Response to Submissions

Section 4.55(1A) Modification – Approved signage at the Overseas Passenger Terminal (Tenancy 5) at Circular Quay West in The Rocks (SSD 7683 MOD 1)

Response to City of Sydney Council's submission on SSD 7683 MOD 1

Level 1 Floorplan

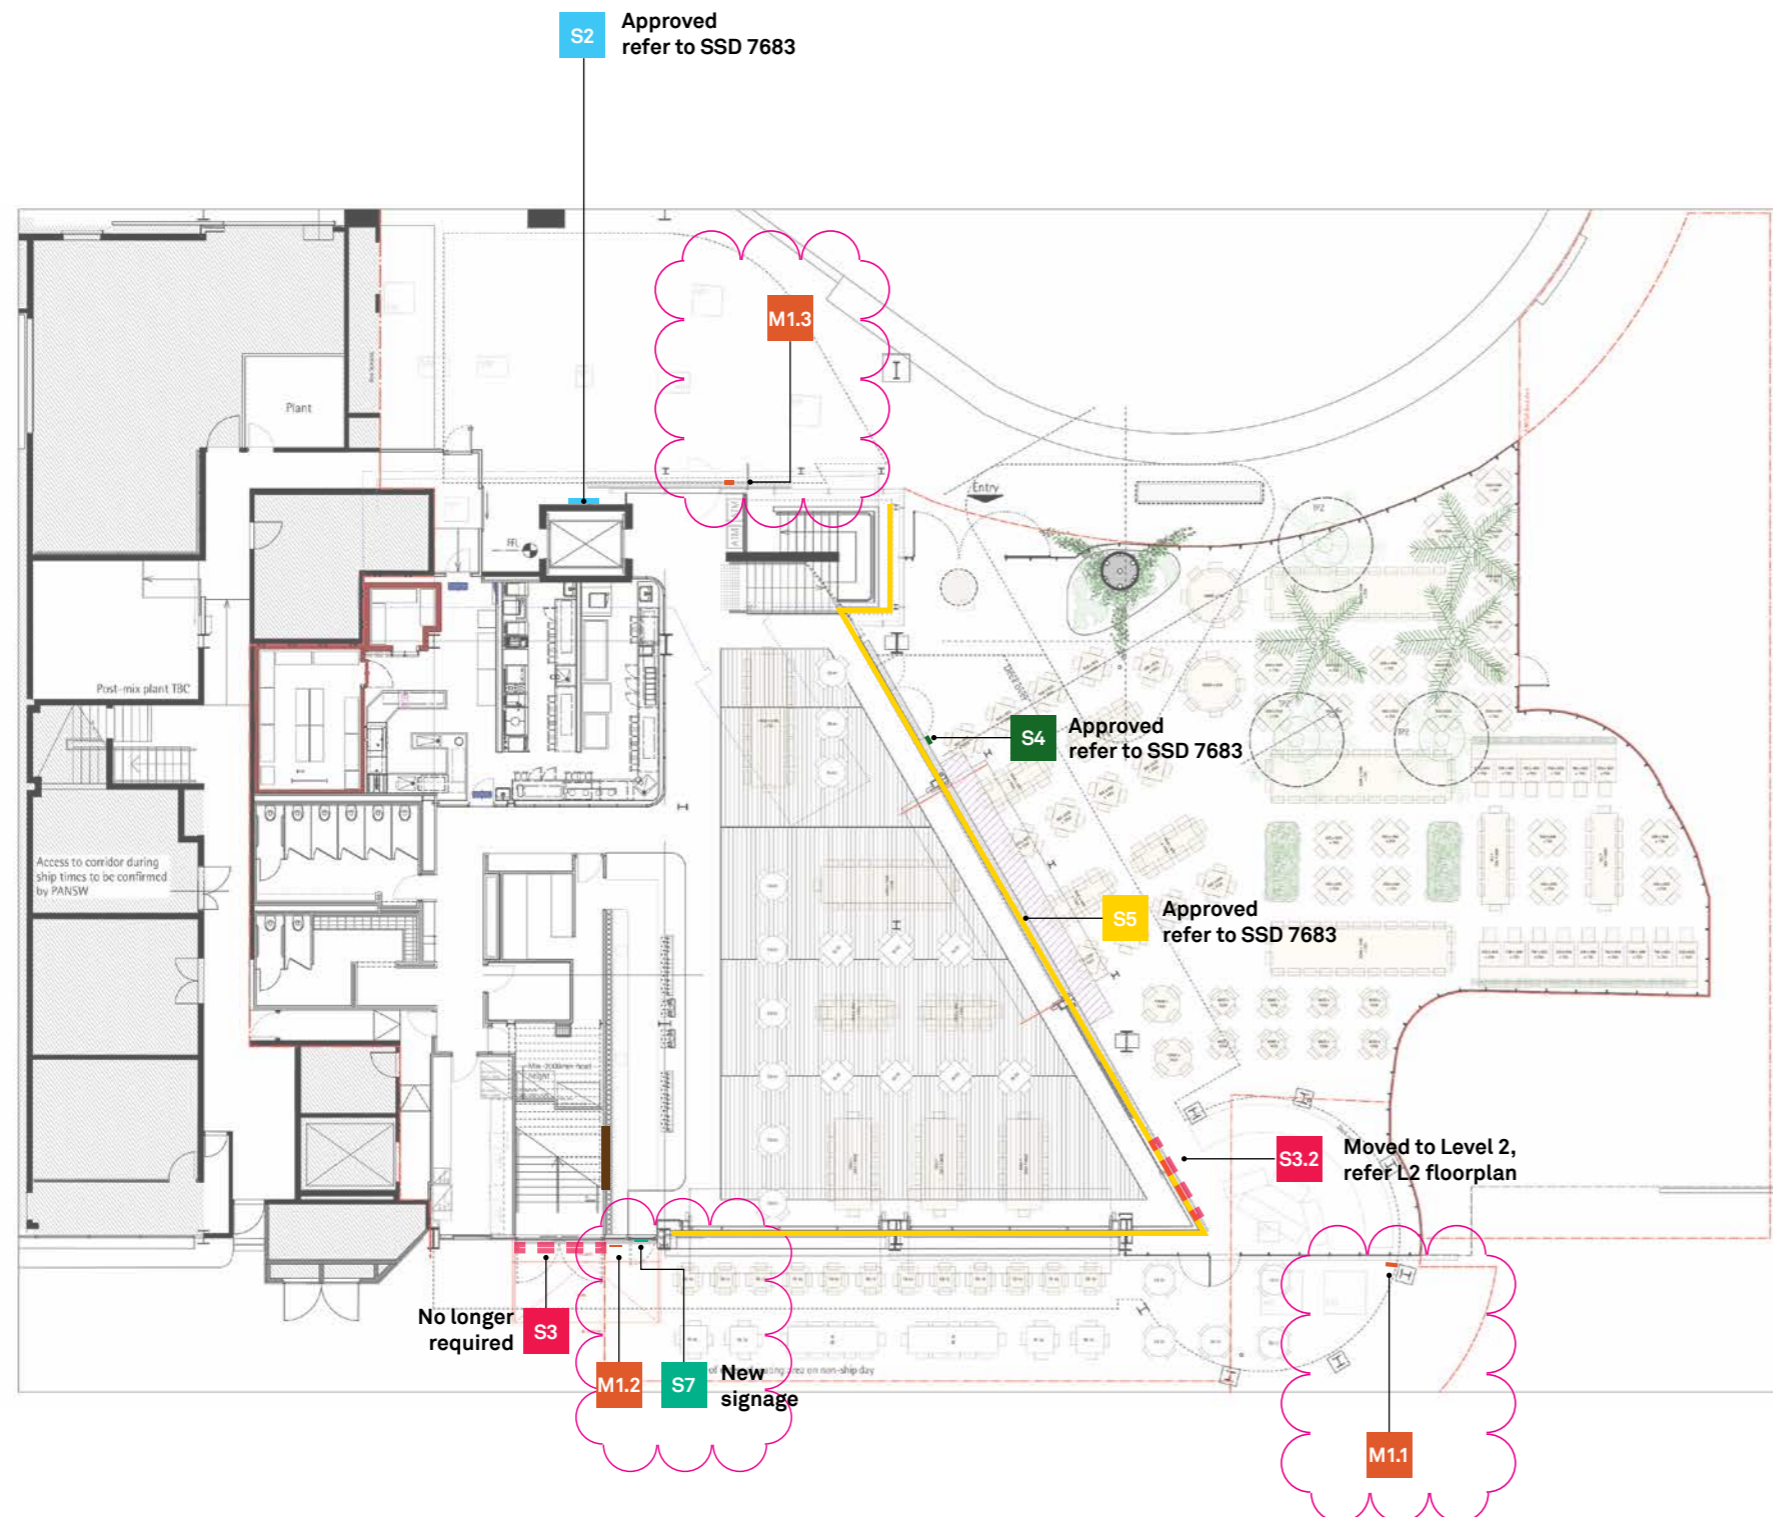
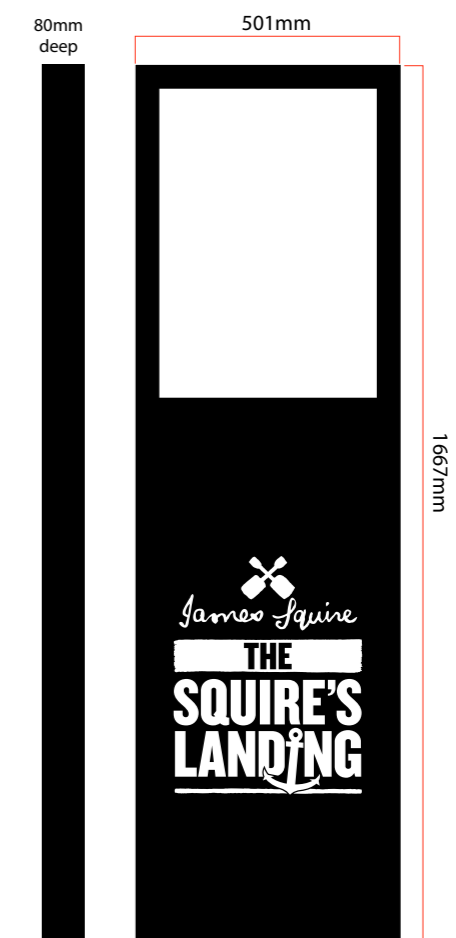
Issue raised	Response
Accuracy of documentation	
<p>The submitted plans contain inaccuracies in terms of the approved signage, both in terms of showing signage in correct locations, and showing all existing approved signage on all elevations. This should be amended for a complete assessment.</p>	<p>The revised signage plans submitted with this RtS amend a number of minor errors and misdescriptions on the plans submitted with the SEE.</p> <p>The location of all existing and proposed signage is shown on the revised plans to enable the Department to undertake a comprehensive assessment of the modification application.</p> <p>It is noted that the location of all existing signage is generally in accordance with the signage plans that were approved under SSD 7683.</p>
Signage	
<p>The quantum of proposed menu signs appears to too large and would result in visual clutter in the area. Menu signage should only be located adjacent to the two main entry areas. The City objects to the approval of more than two menu signs.</p>	<p>In response to Council's concerns regarding visual clutter, the number of freestanding menus has been reduced from five to three in total.</p> <p>The three freestanding menus are suitably located at the main entry points to the restaurant and the outdoor seating/dining area.</p> <p>The modification application included an assessment against the criteria of <i>State Environmental Planning Policy No 64 – Advertising and Signage</i> (SEPP 64). Key findings of this assessment determined that:</p> <ul style="list-style-type: none"> the proposed signage and menu stands are compatible with the existing character of the area being a location that currently includes various restaurants and bars within the Overseas Passenger Terminal (OPT) and high pedestrian activity surrounding the site;

We note that the modification application received one submission from the City of Sydney Council (Council) dated 11 December 2018. In response to Council's concerns, the modification application has been amended to include three freestanding menu signs, reduced from five freestanding menu signs (as originally proposed). A detailed response to the issues raised by Council is provided at **Appendix 1**.

East elevation

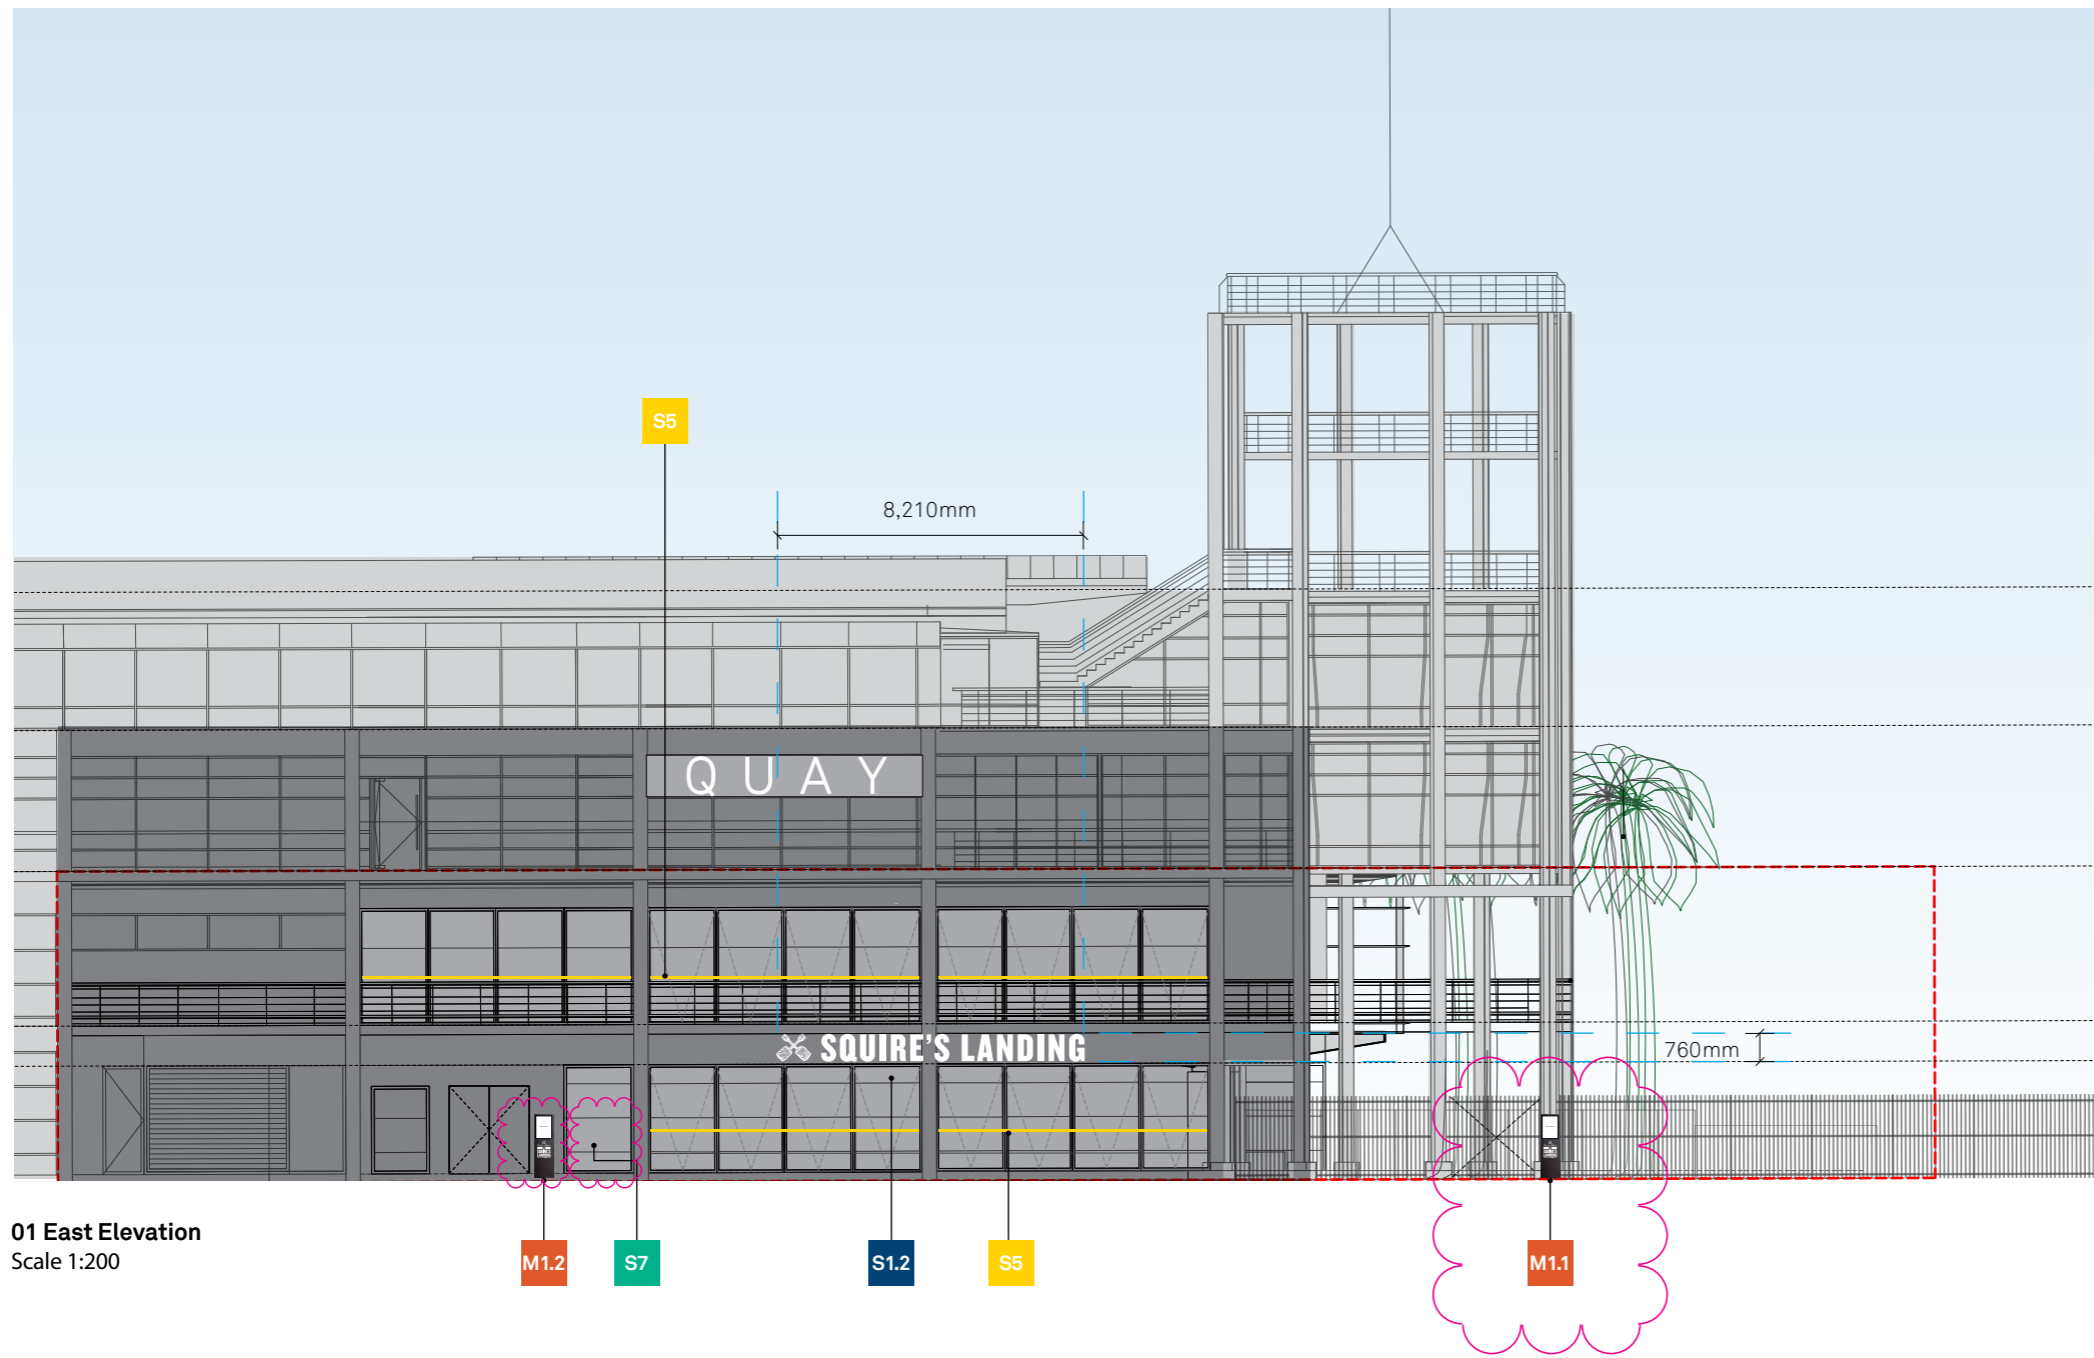
Proposed sign ‘S7’ should be clarified in terms of its dimensions.	Proposed ‘Sign ‘S7’ on the ground floor entry door is proposed to be 500 mm in height and 400 mm in width. Refer Page 3 of the revised plans (East Elevation).
